Engineers Comments Regarding Surface Water Drainage

Application Reference:	BN/76/26/DOC	Reviewer Reference:	ADC/EXT2/113
Planning Officer:	Amber Willard	Date of Review:	30/07/2026
Site Name:	Land South Of Wandleys Lane Eastergate PO20 3SE		
Application Description:	Approval of details reserved by condition under BN/46/25/PL relating to conditions 4- Surface Water Drainage and 9- Maintenance & Management of Sustainable Drainage Scheme.		
Assessment Number:	1

Response	Condition 4: Further information required Condition 9: Further information required
-----------------	---

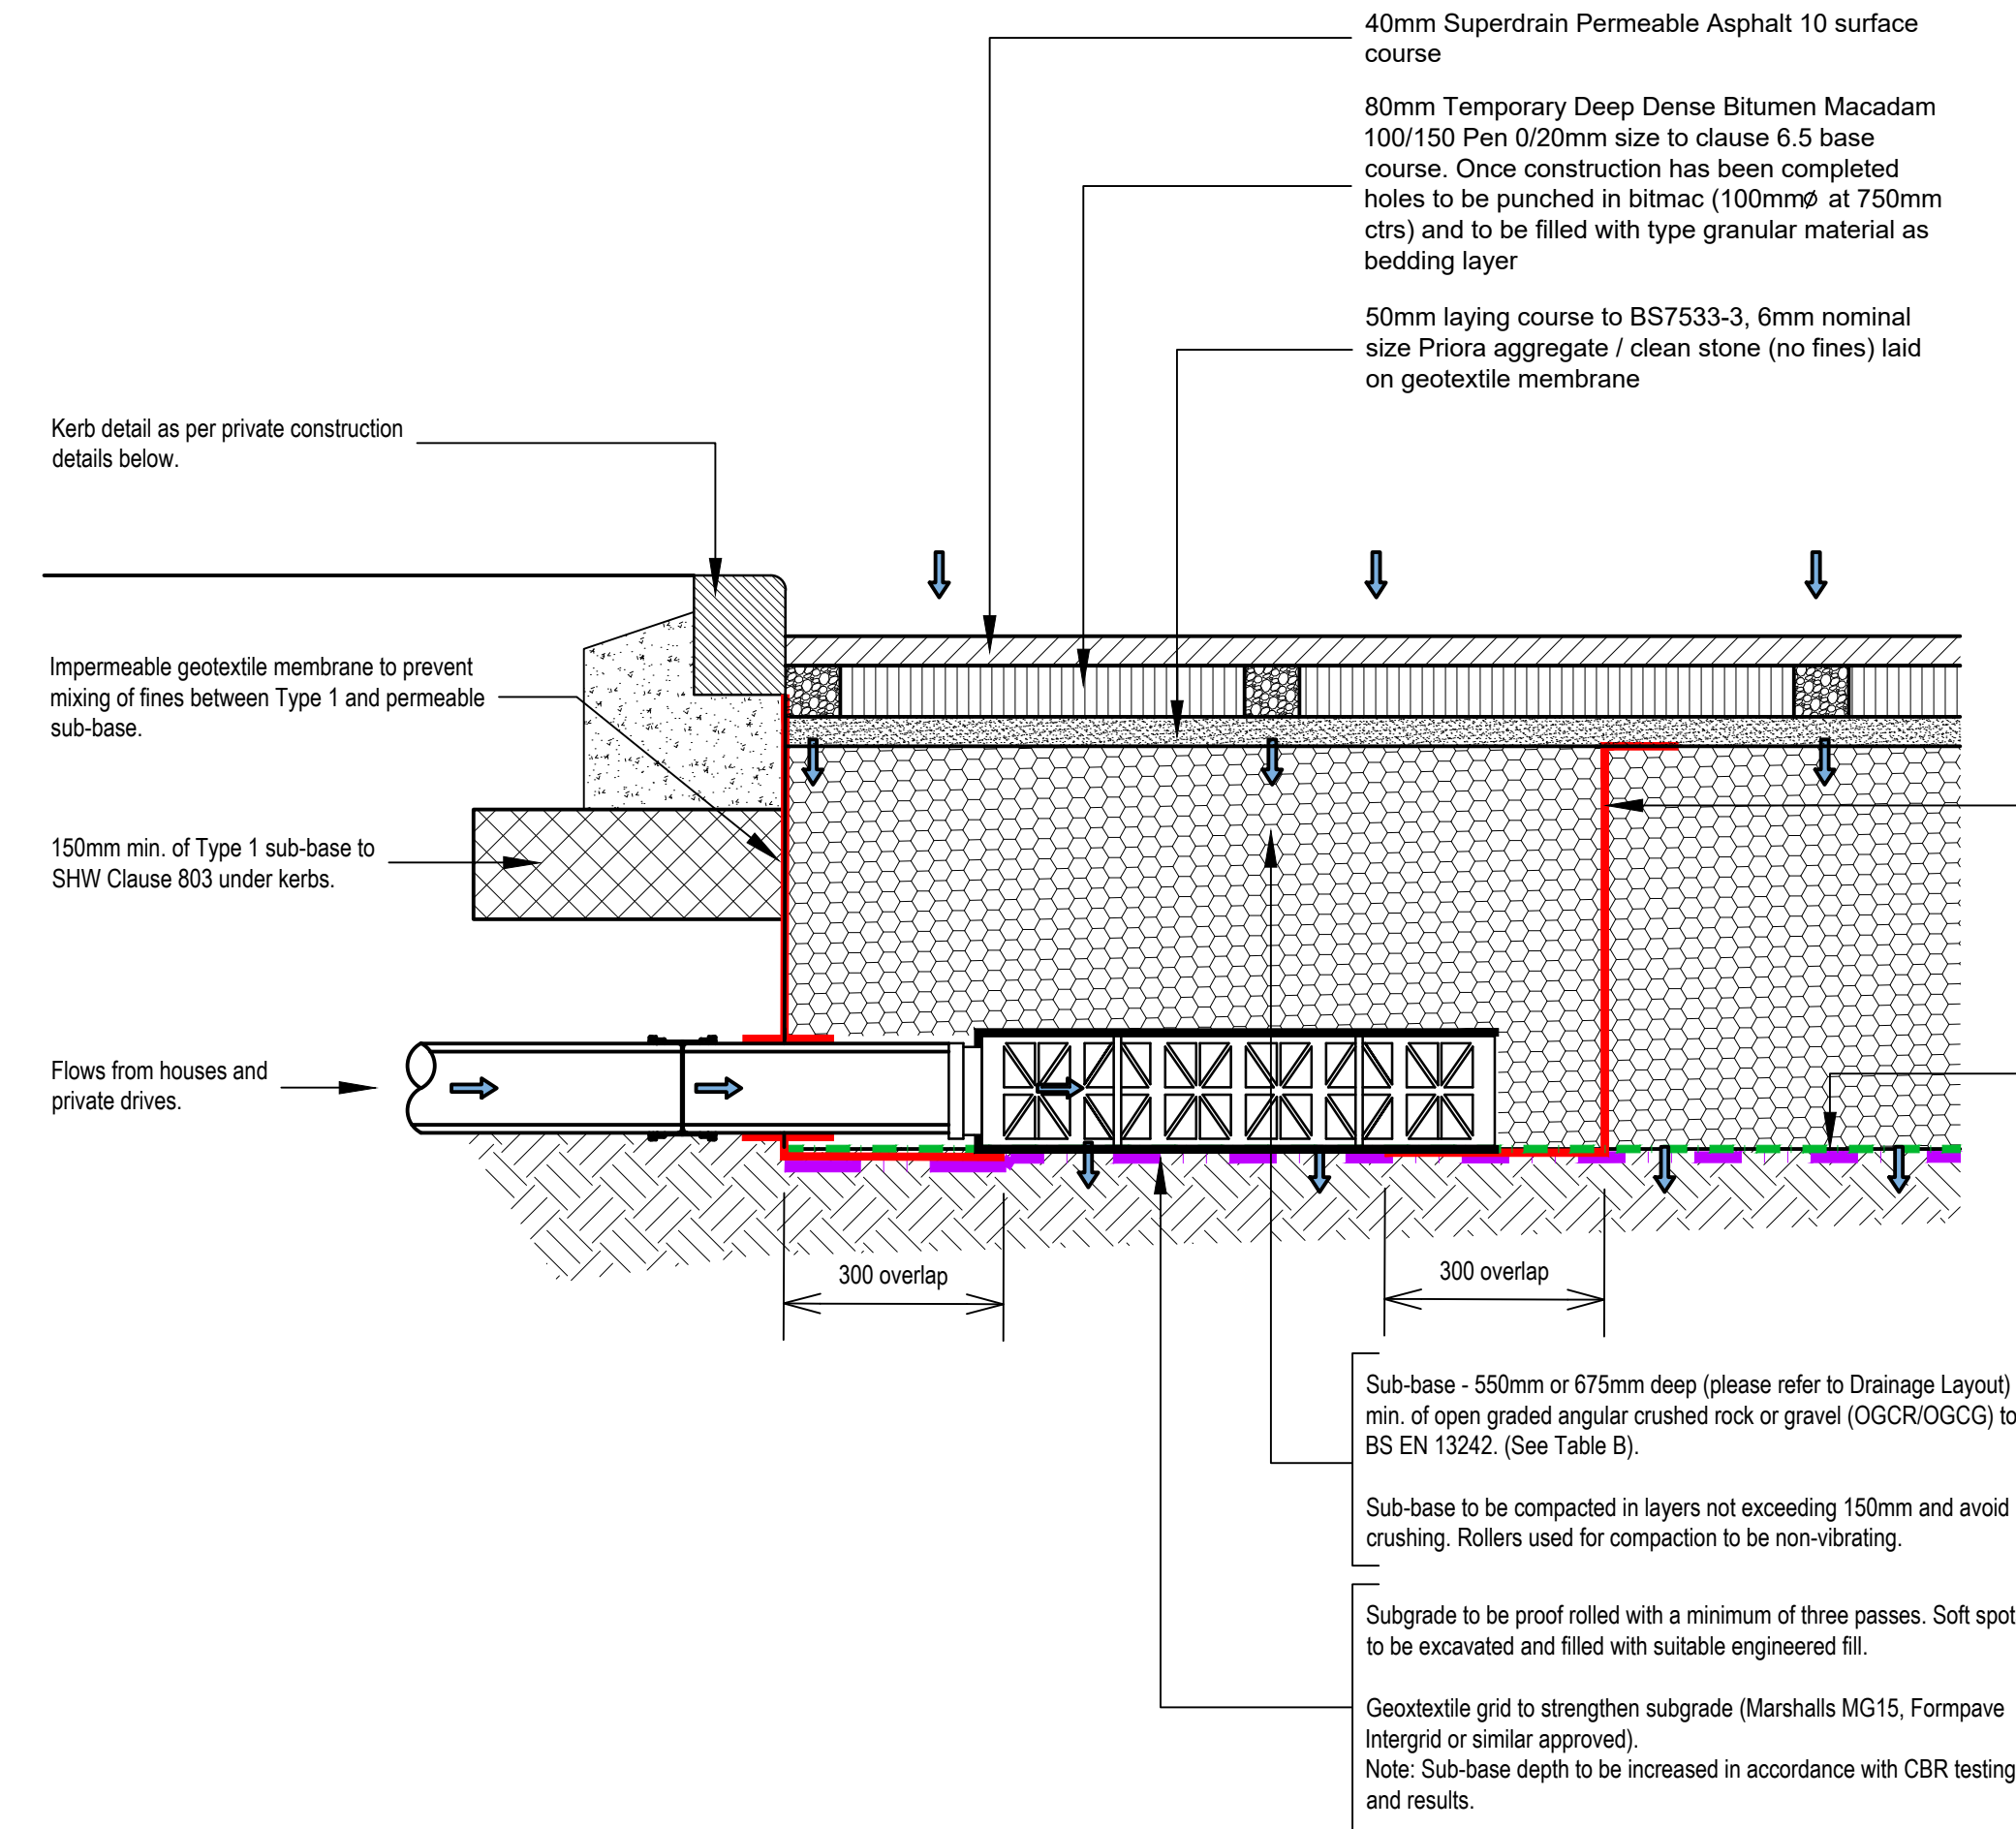
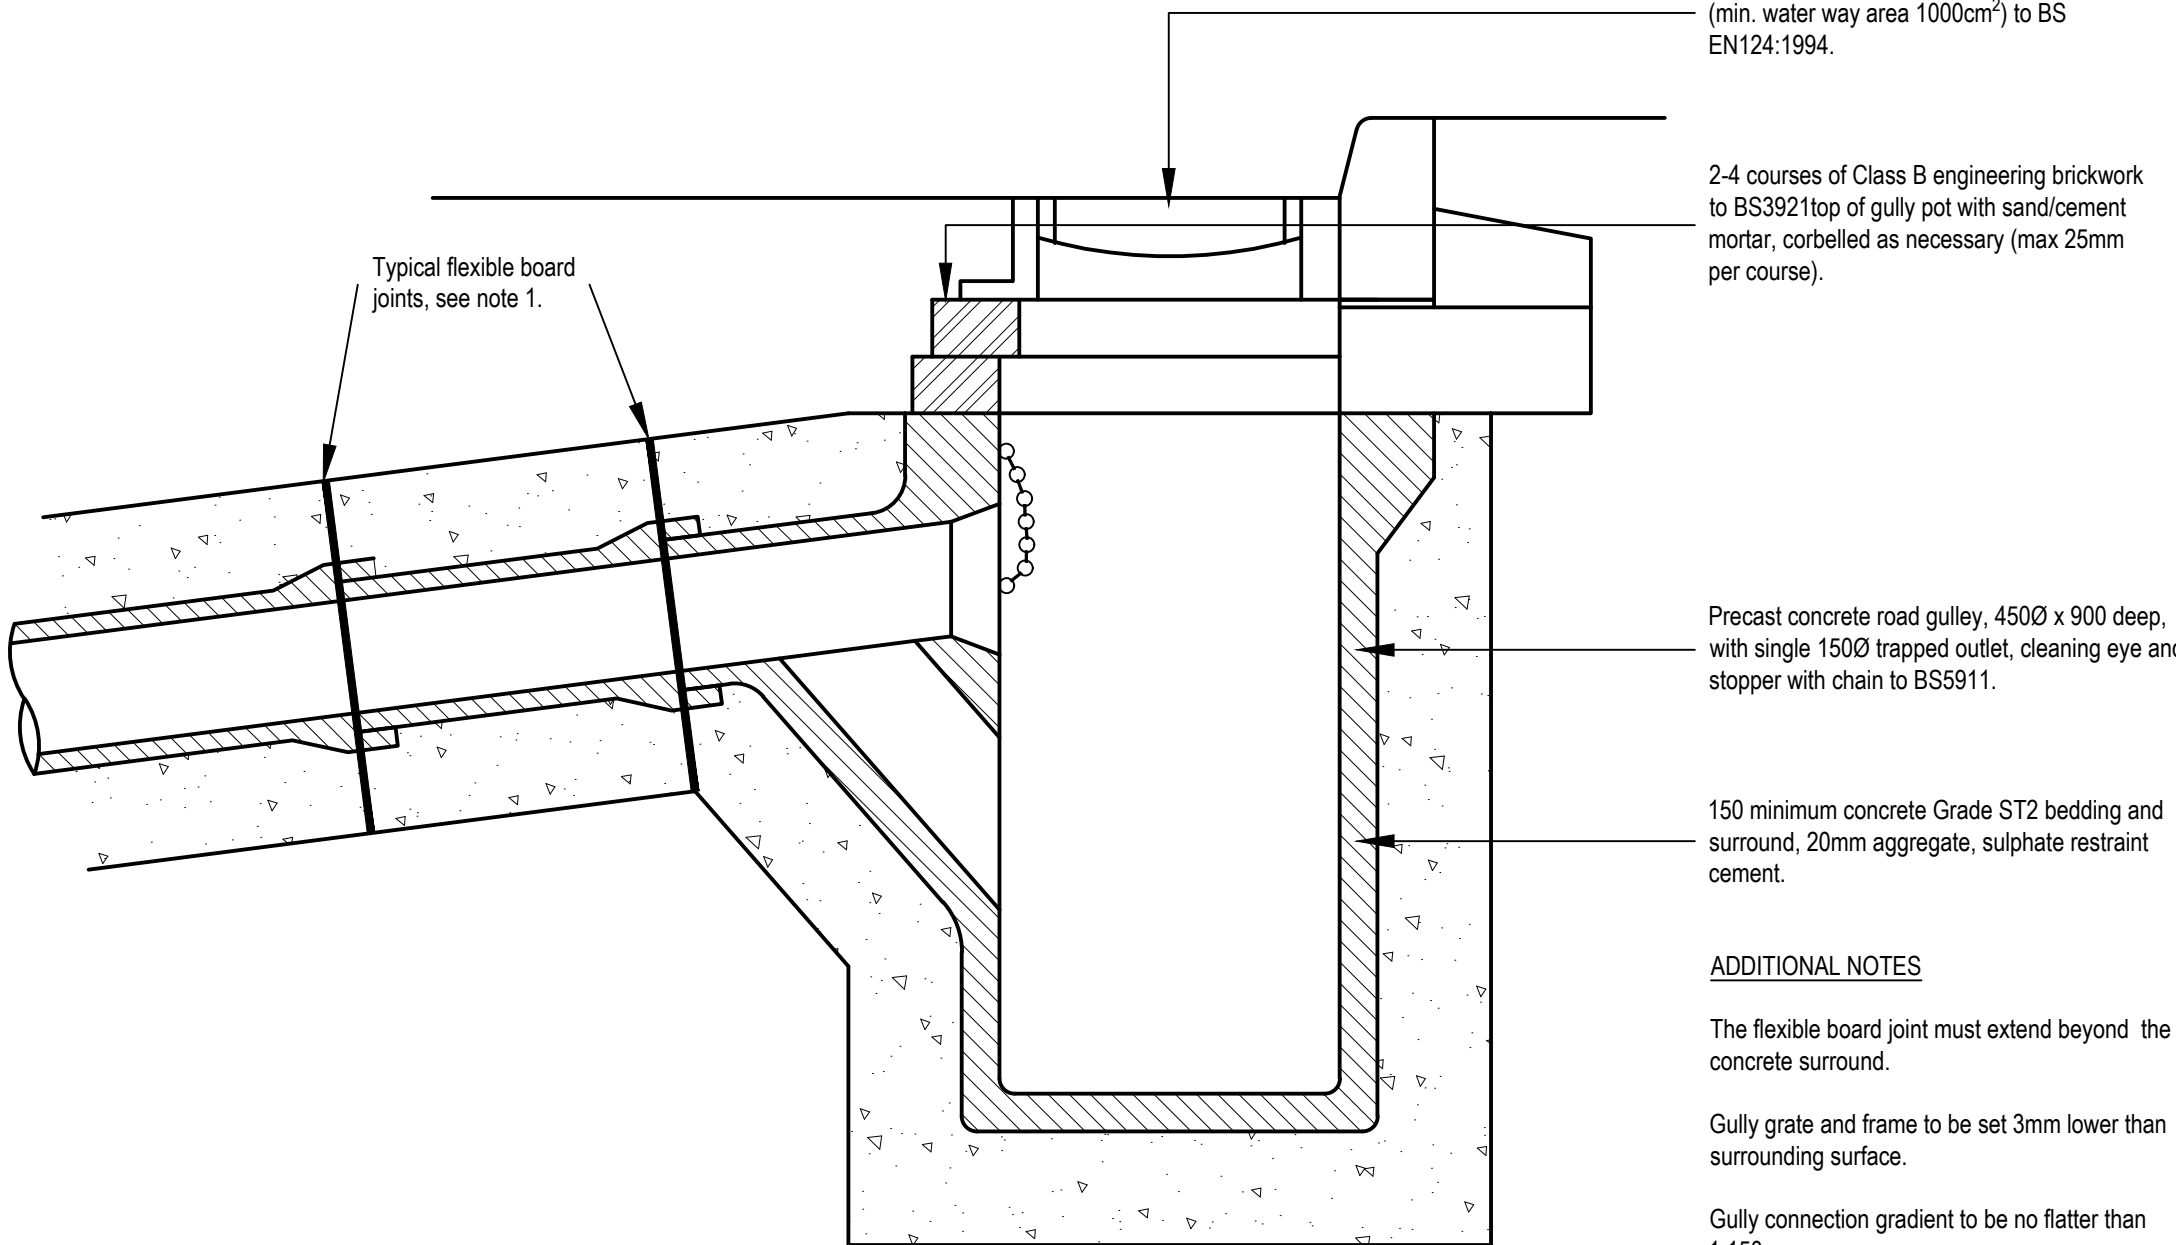
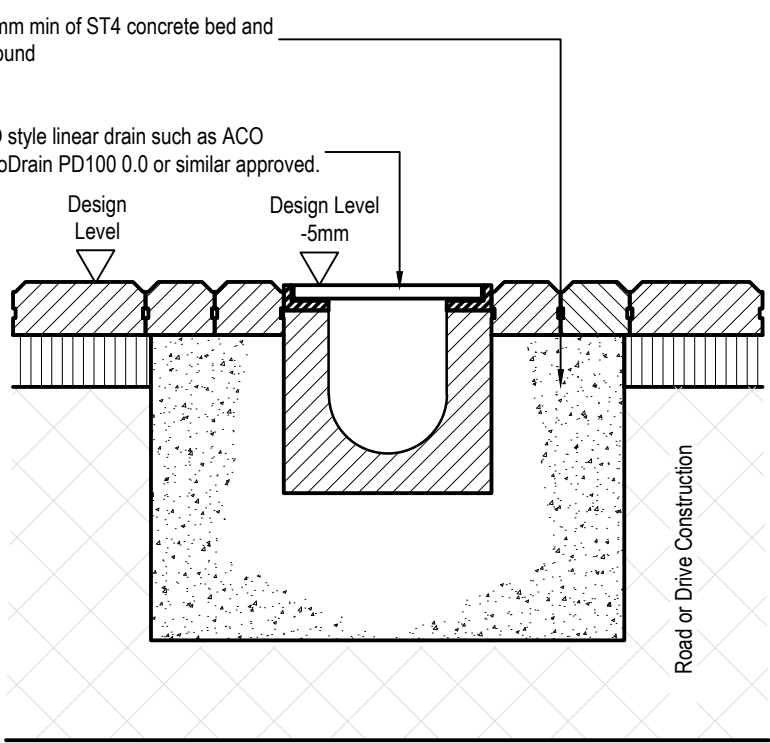
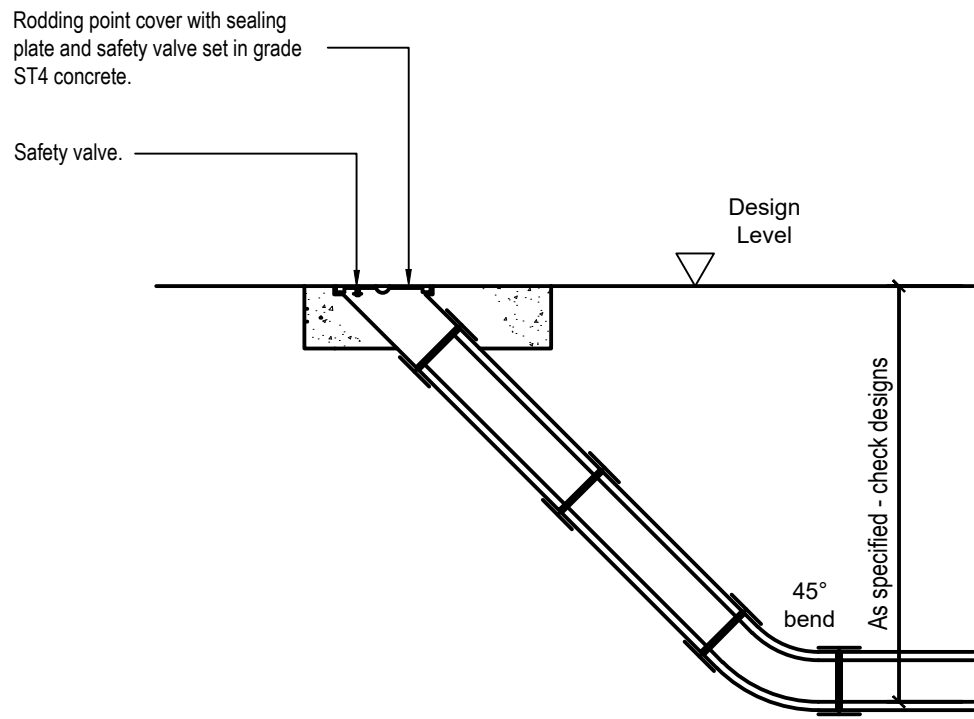
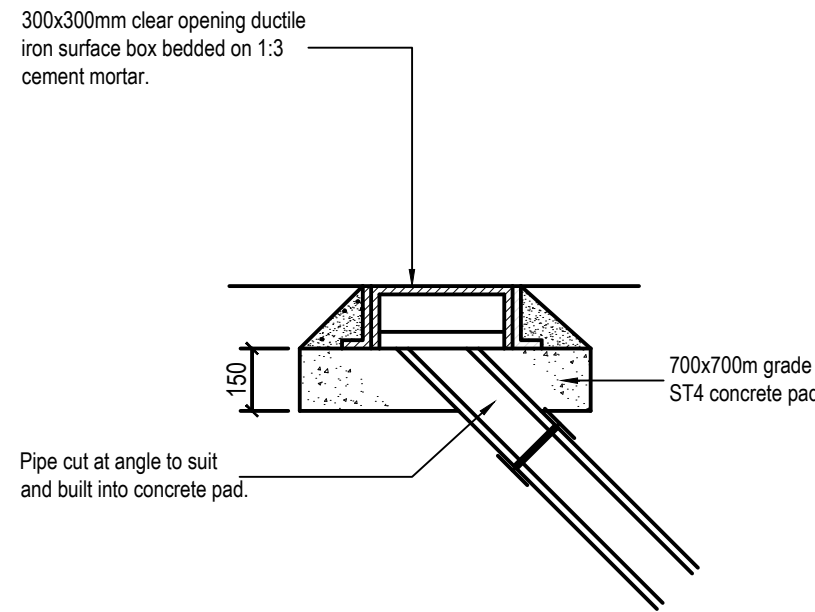
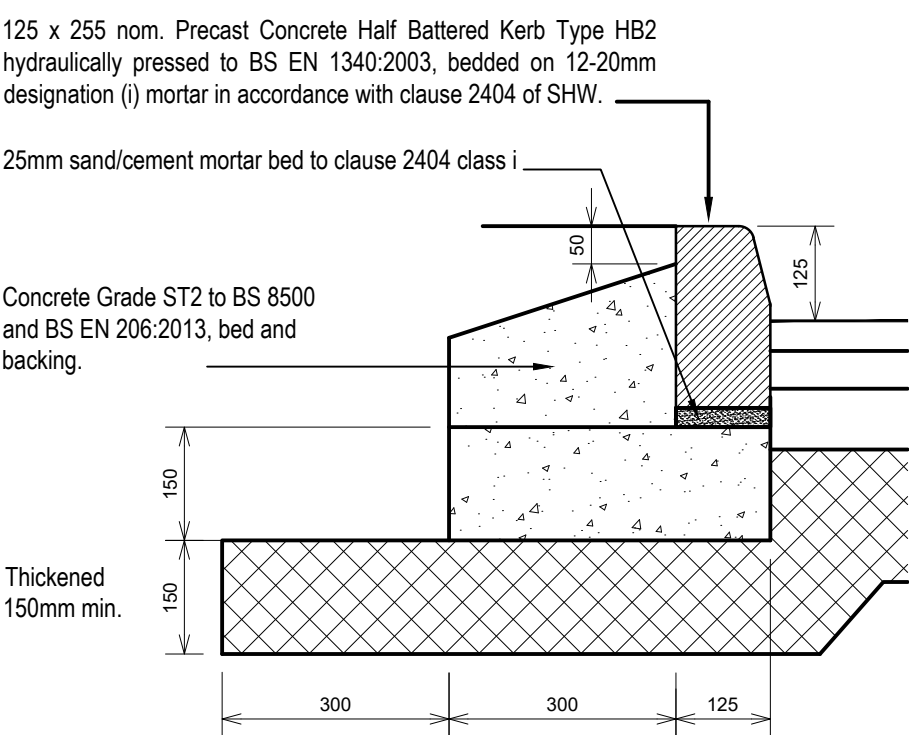
14.	Construction detail updated. Please refer to drg no. 476988-911_P03 - Construction Details-- Sheet 1.	Noted. Comment closed.			
15.	Detail updated with correct reference. Please refer to drg no. 476988-911_P03 - Construction Details-- Sheet 1.	Noted.

18.	Construction detail updated. Please refer to drg no. 476988-911_P03 - Construction Details— Sheet 1.	Noted. Comment closed.			
19.	Note added to construction details. Please refer to drg no. 476988-911_P03 - Construction Details-- Sheet 1.	Noted. Comment closed.
